## Deadline 4 Submission from Bryan Robinson (IP ID 20028154)

The following are comments against the Applicant's replies to my earlier observations on specific issues in the Inspector's questions at EXQ1 and resulting from ISH2 hearings.

### Junction Design

Figure 3.2 – Proposed Wood Lane Interchange

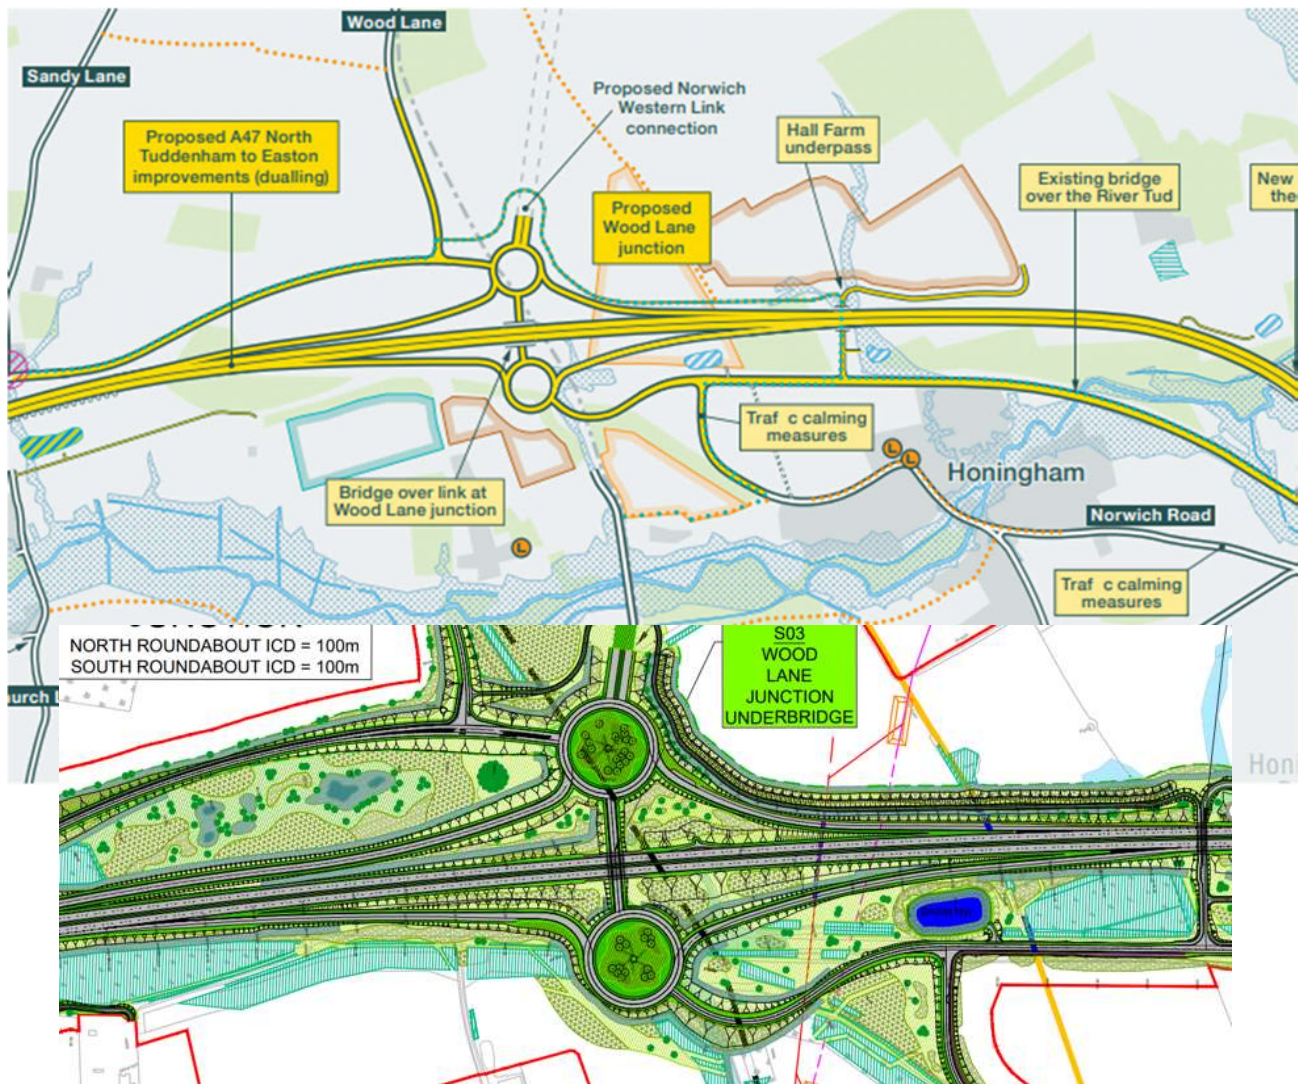
If it is accepted that there is the possibility of no NWL, the design implications must be made available to the Inspector, in particular the outline for a revised design of the Wood Lane junction and the side road strategy.

Consultants engaged by Interested Parties have made statements that they consider the Wood lane junction to be oversized without the NWL. The answer to the question by the Inspector at ISH2 of whether the Wood Lane junction design would change without the NWL was studiously avoided by the Applicant with references to designs following DMRB.
